# Rezoning Transportation Analysis

Petition Number: 2025-086

**From: Jake Carpenter, PE**

PENCE ROAD INDUSTRIAL SITE REZONING PLAN (2025-086)

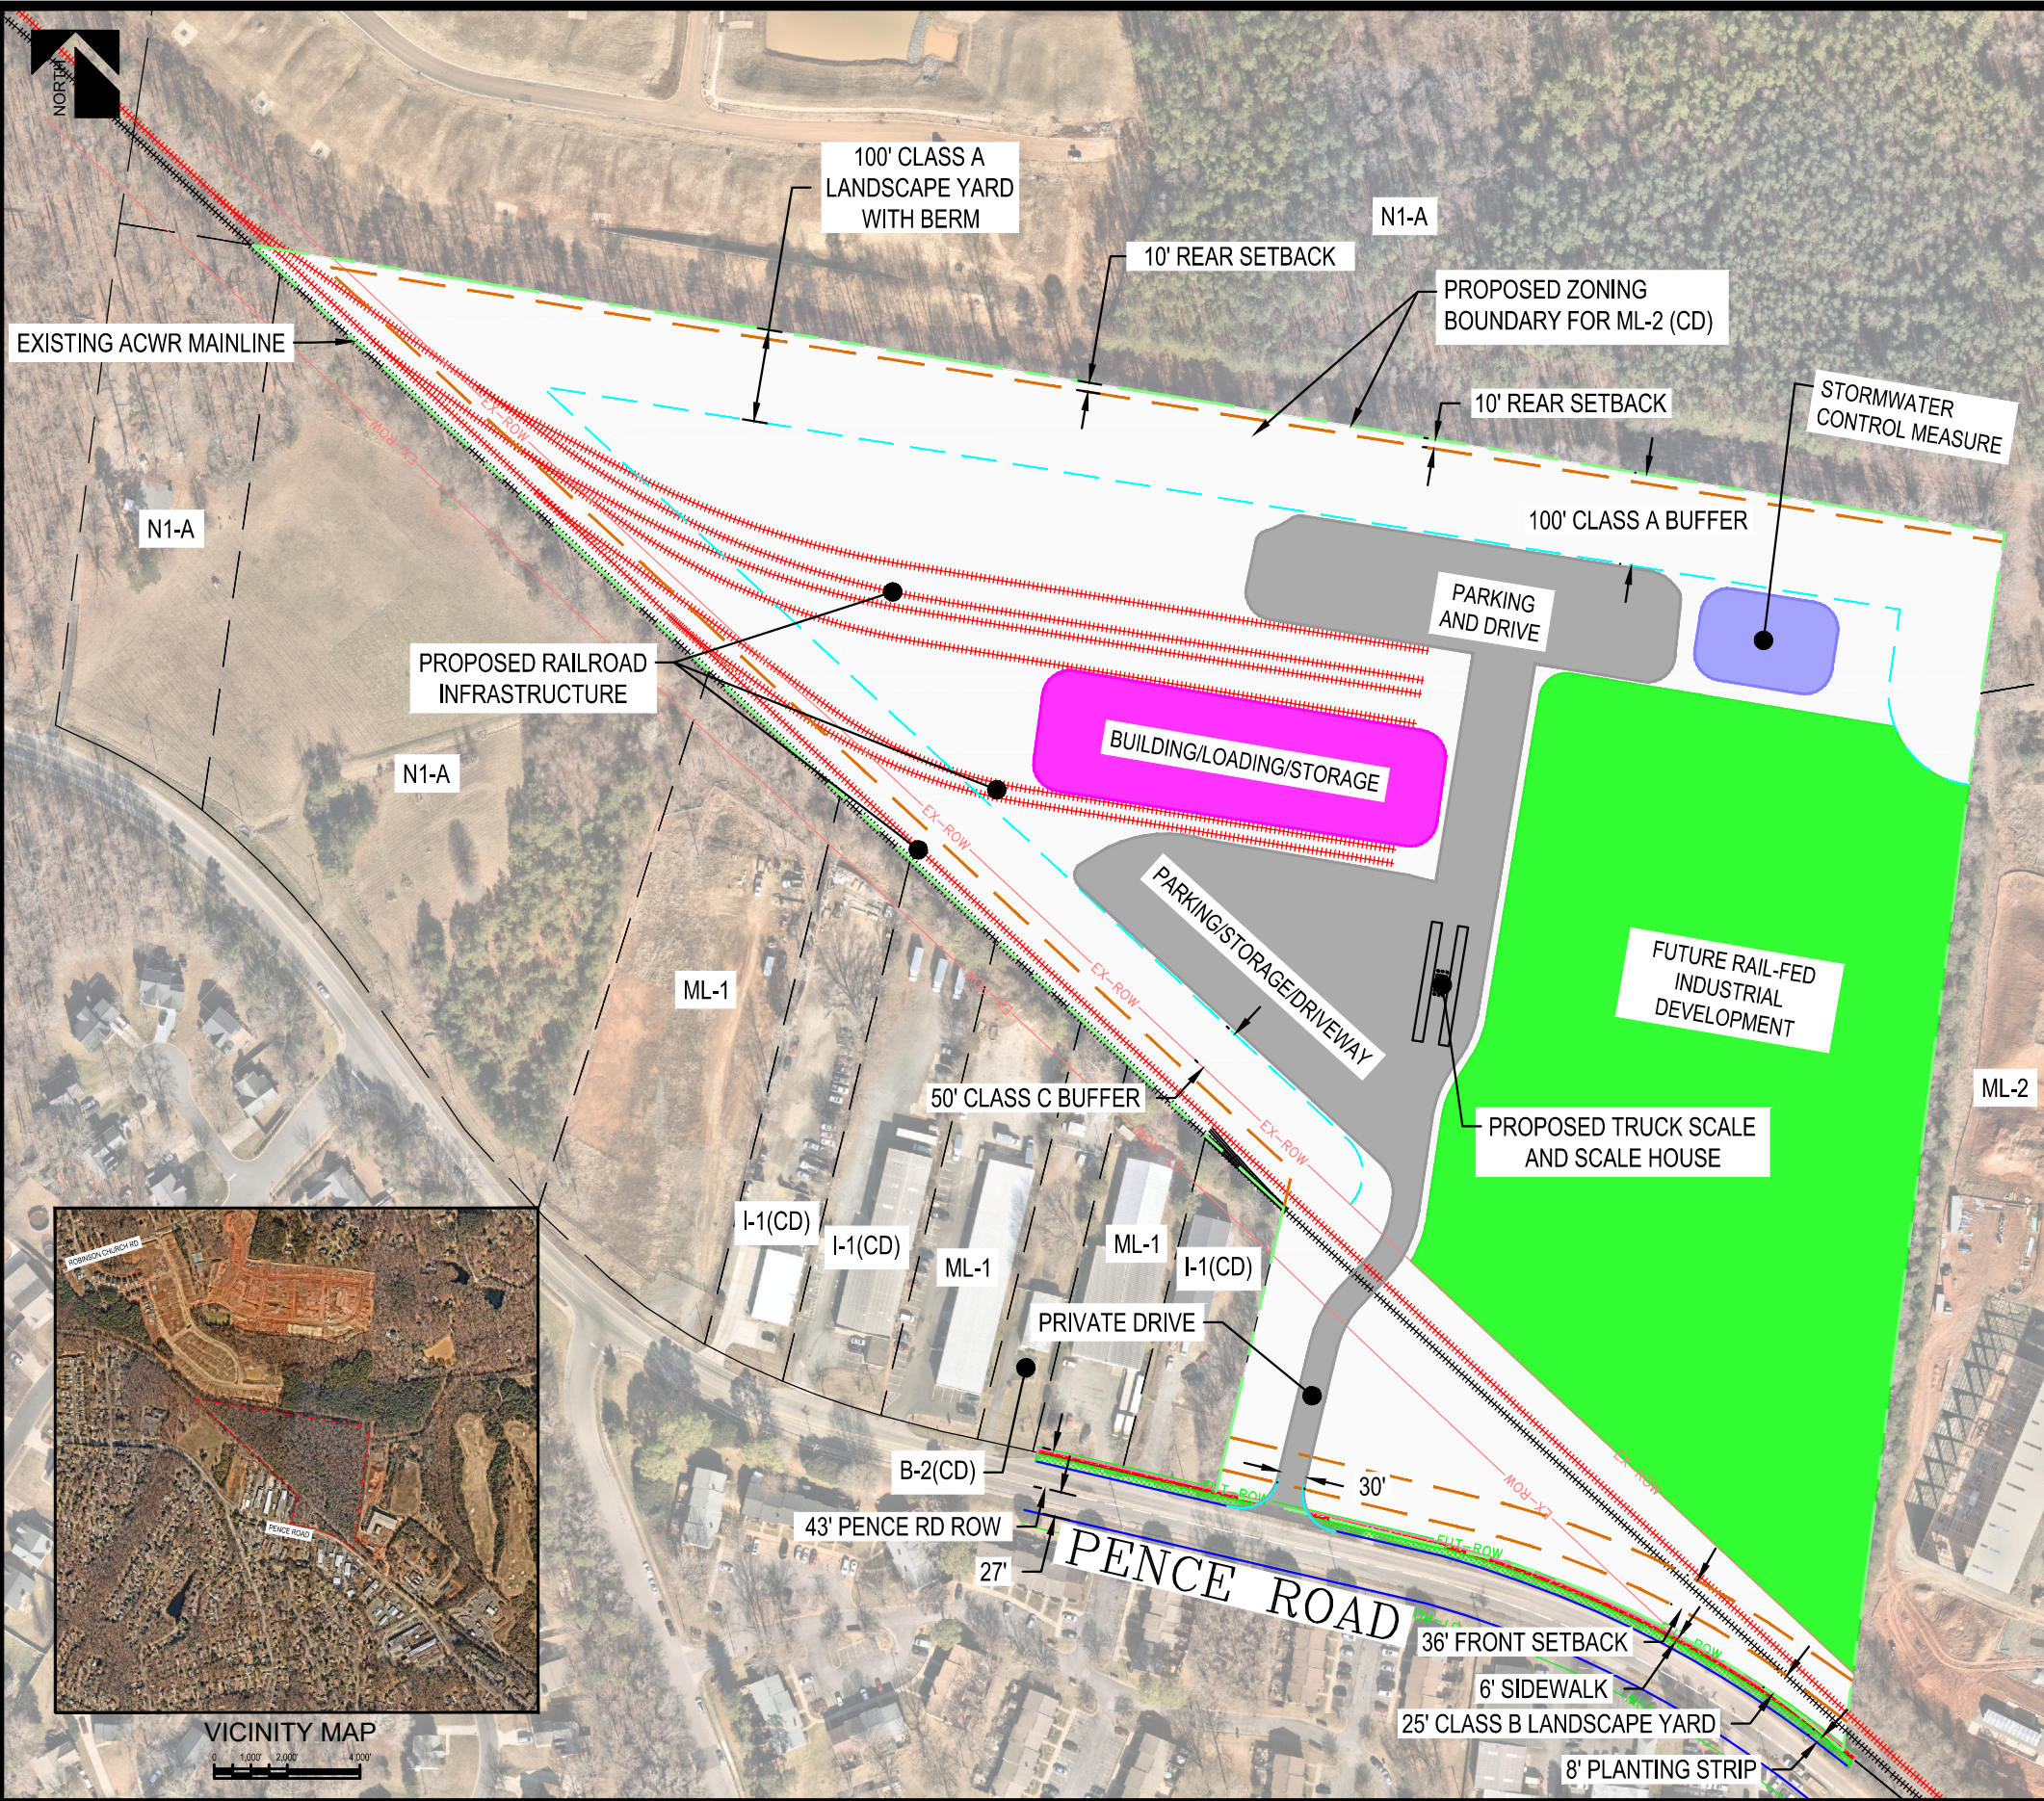
- Pence Road:** Curb and gutter is to be constructed in the future back of curb location in accordance with the Charlotte Streets Map at 27-feet from the roadway centerline.

Label and dimension the curb and gutter from the centerline for each road on the site plan.

**Clarifying comment 09-24-25: Revise site plan by placing 27-foot dimension towards your site and add a callout stating that is the proposed back of curb. Show curb and gutter being placed along sites frontage.**

**Clarifying comment 09-24-25: Revise site plan and conditional note(s) by showing a 5-foot bike lane and 3-foot buffer. Callout striping on the site plan and revise condition note(s) to commit to installing the bike lane per Charlotte Streets Map. Currently the 27-foot dimension is towards the opposite side of the road.**
